Appeal Decision

Appeal Ref: APP/T2350/W/23/3325434

Land adjacent to Miles Hill, Moor Lane, Billington BB7 9JH

- The appeal is made under section 78 of the Town and Country Planning Act 1990 against a refusal to grant approval required under Schedule 2, Part 3, Class Q of the Town and Country Planning (General Permitted Development) (England) Order 2015 (as amended) (the GPDO).
- The appeal is made by Mr Tom Procter against the decision of Ribble Valley Borough Council.
- The application Ref 3/2023/0226, dated 15 March 2023, was refused by notice dated 5 May 2023.
- The development proposed is conversion/redevelopment of two agricultural buildings into 2 dwellings.

PROPOSED SITE PLAN

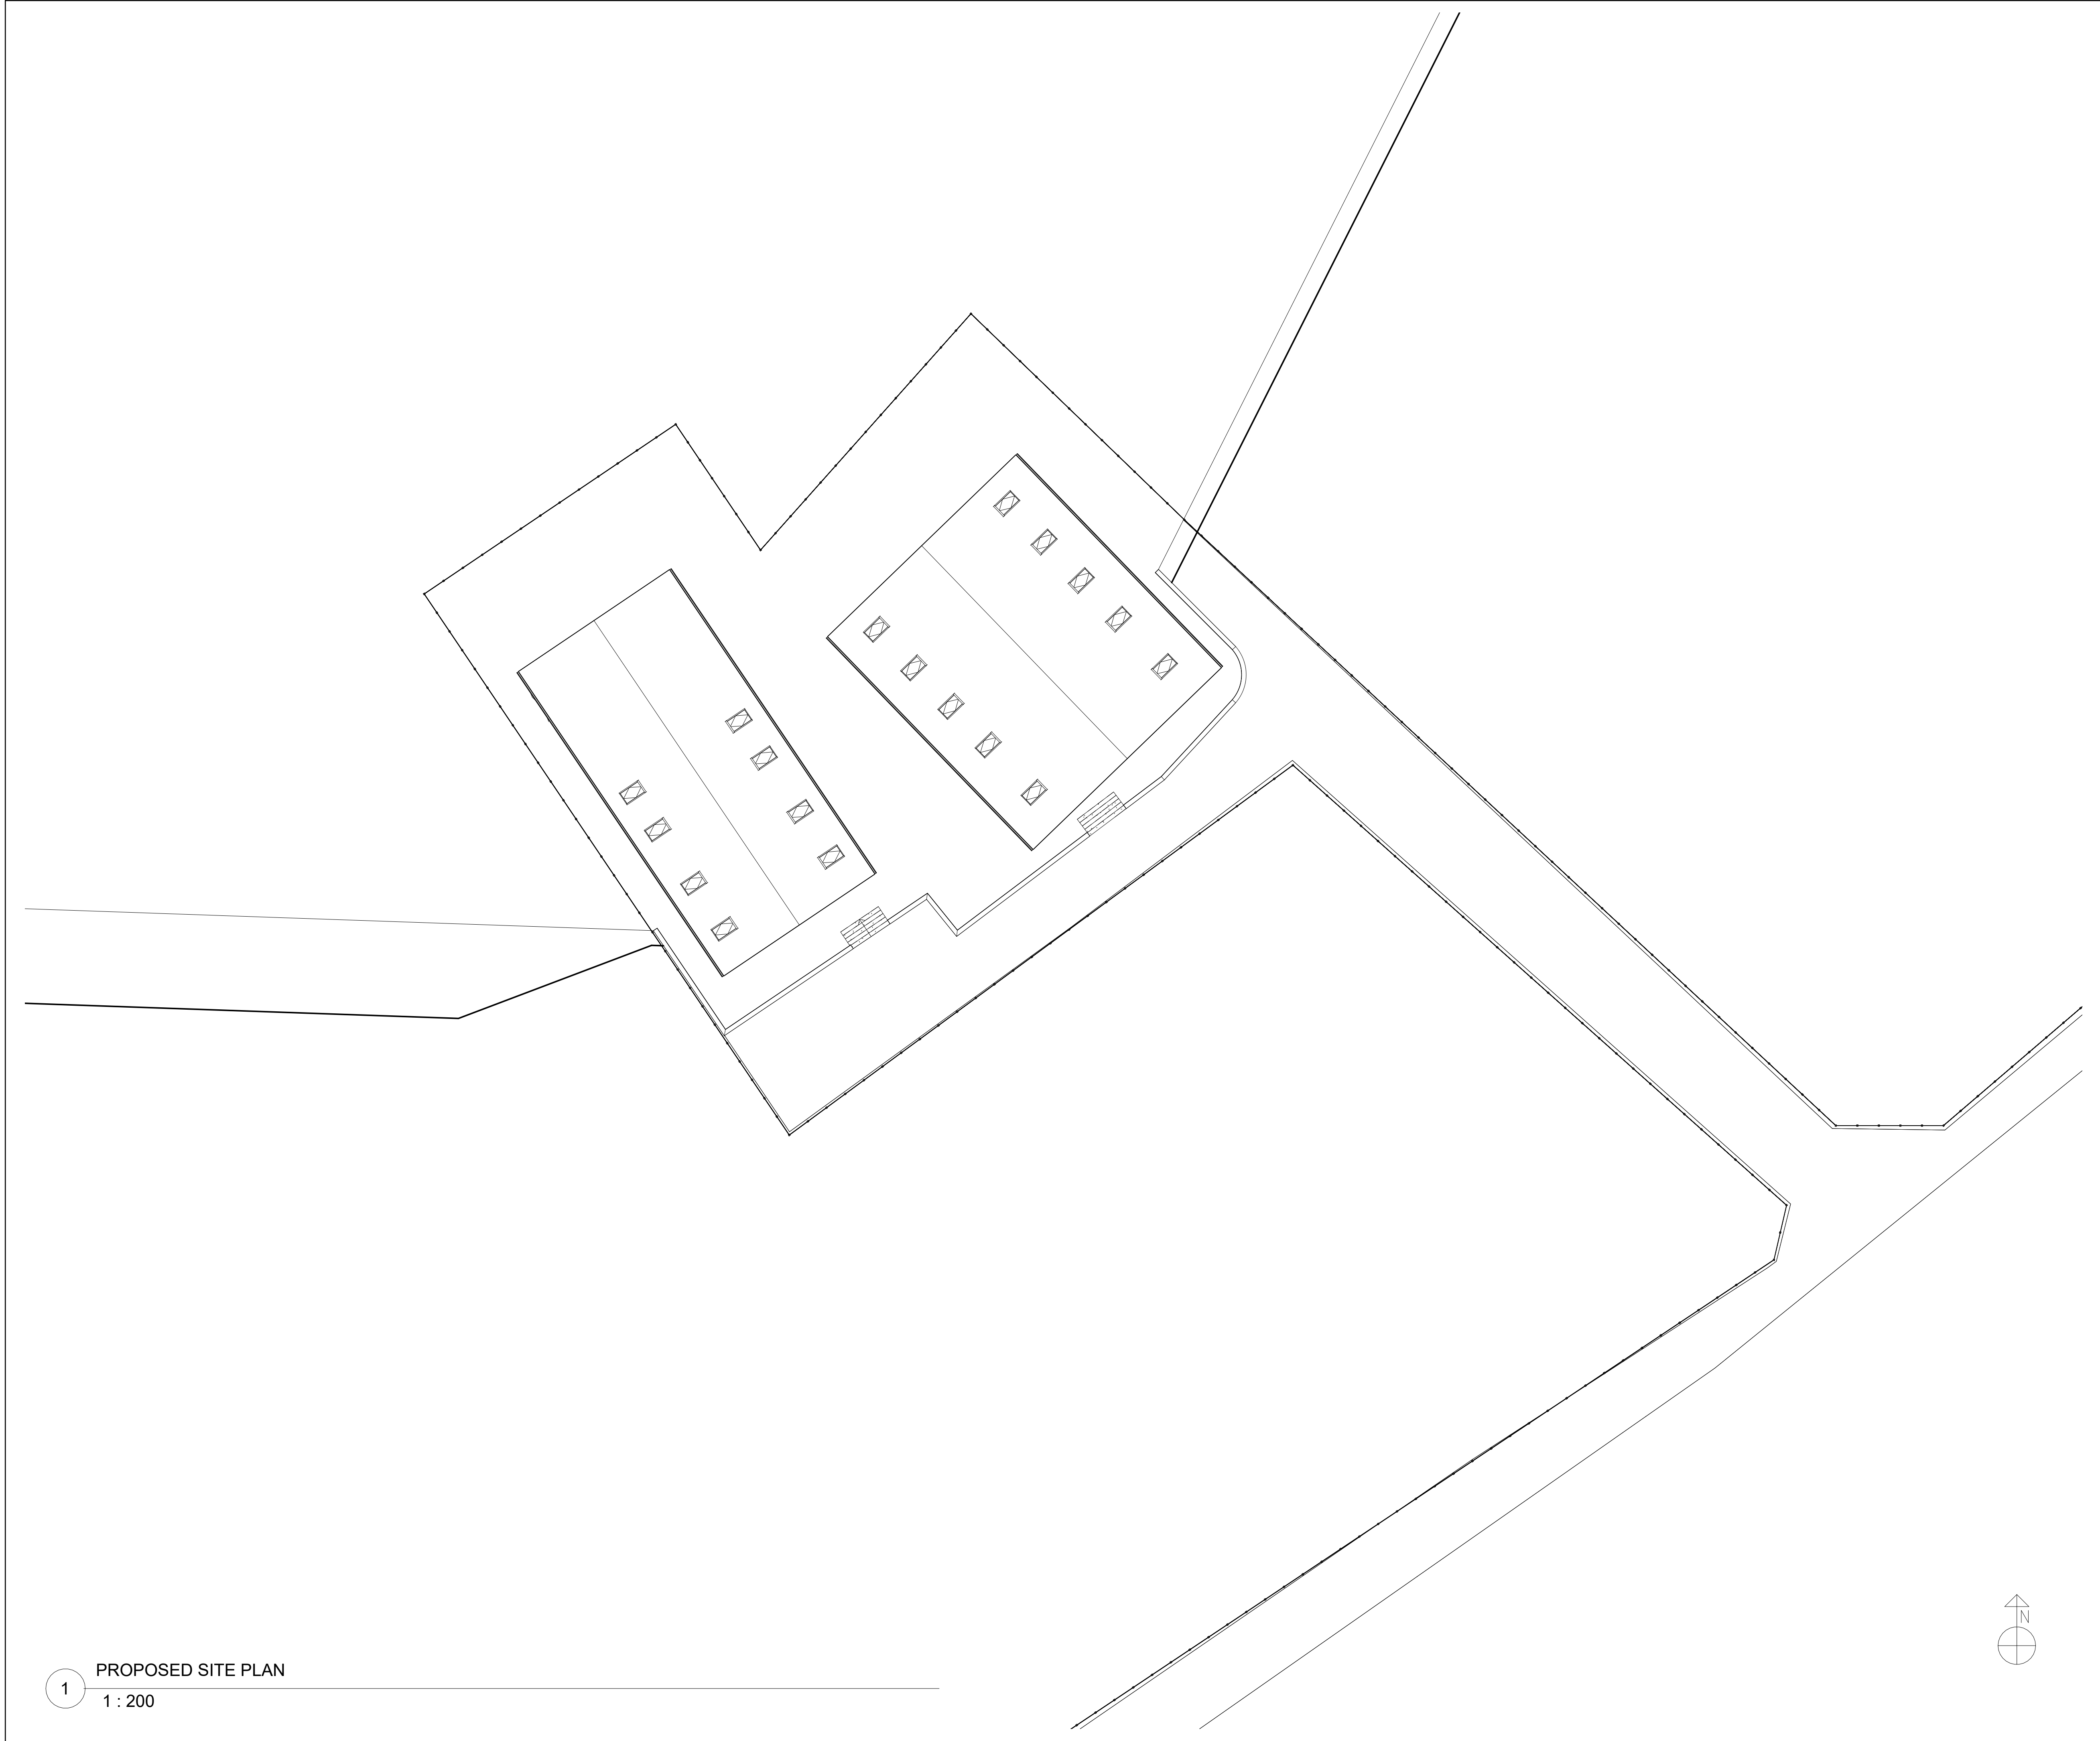
11. The buildings are parallel to one another. They occupy a sloping site and their south east gable ends are set below the surrounding hardstanding, resulting in an abrupt change between the external and internal floor levels. In addition to the works to convert the buildings, there would also be extensive lowering of ground levels around the south east elevations of both barns and across the intervening land. The higher lying land along the south east boundary would then be separated from the lower lying land immediately around the buildings by a long retaining wall with steps leading down to the front of both buildings.

13. The main access into the easternmost barn, Barn 1, would be via a door into a hall part way along its north east side elevation and beyond the end of the retaining wall. As such, the external ground works are not necessary to provide access into Barn 1. There would be a further door serving a utility room in the recessed part of Barn 1 beneath the south east gable end canopy. In the absence of the external ground works, this door would not be easily accessible from the south east due to the abrupt change in ground levels at the edge of the existing building envelope. However, it would not be the main or visitor entrance from the parking area and it would be accessible from the already lower lying land to the south west of the building.

14. The main access to Barn 2 would be via a door in its recessed canopied south east gable end. Taking into account the size of the proposed canopied area and that the existing access is provided by an internal ramp, the change in levels could be similarly managed by a small scale internal intervention within the building envelope which could include raising of internal levels, steps or ramp. This could be secured through the imposition of a planning condition. The section of retaining wall between the buildings would appear to serve little functional purpose in terms of the residential use of the buildings, notwithstanding it may be a more aesthetically pleasing solution than the existing agricultural hardstanding. For these reasons, I find that the buildings could be converted and function as dwelling houses without the external groundworks proposed. The ground works and the retaining wall are not demonstrably reasonably necessary for the buildings to be converted.

15. In summary, the external ground works do not appear to be a type of building operation specifically permitted under paragraph Q.1, nor would they be partial demolition or de minimis engineering operations. To the extent proposed, the lowering of land and the retaining walls and steps do not appear reasonably necessary to convert the buildings for the purposes of paragraph Q(b).

16. Nevertheless, Paragraph W(13) of the GPDO makes provision for the local planning authority to grant prior approval unconditionally or subject to conditions reasonably related to the subject matter of the prior approval. In this regard, I am mindful that in so far as it affects the buildings, the proposal would meet the requirements of Class Q(b). Moreover, the works to convert the building to residential use would be severable from the proposed external ground works. As such, it would be possible to impose a condition requiring the development to be carried out in accordance with the approved plans but excluding the retaining wall with steps shown on the proposed site plan.

17. The appellant considers that the previous appeal decision establishes that the proposal would meet the requirements of the GPDO in this regard. However, the Inspector simply stated the common ground between the parties and then focussed on the matters in dispute. In the absence of any commentary in relation to the acceptability of the external ground works, the previous dismissed appeal decision does not provide a justification for the proposal.
18. Therefore, I conclude that the proposal would be permitted development under Schedule 2, Part 3, Class Q(b) of the GPDO, with regard to the extent of operations required to convert the agricultural buildings to dwellinghouses, subject to a condition excluding the external ground works.
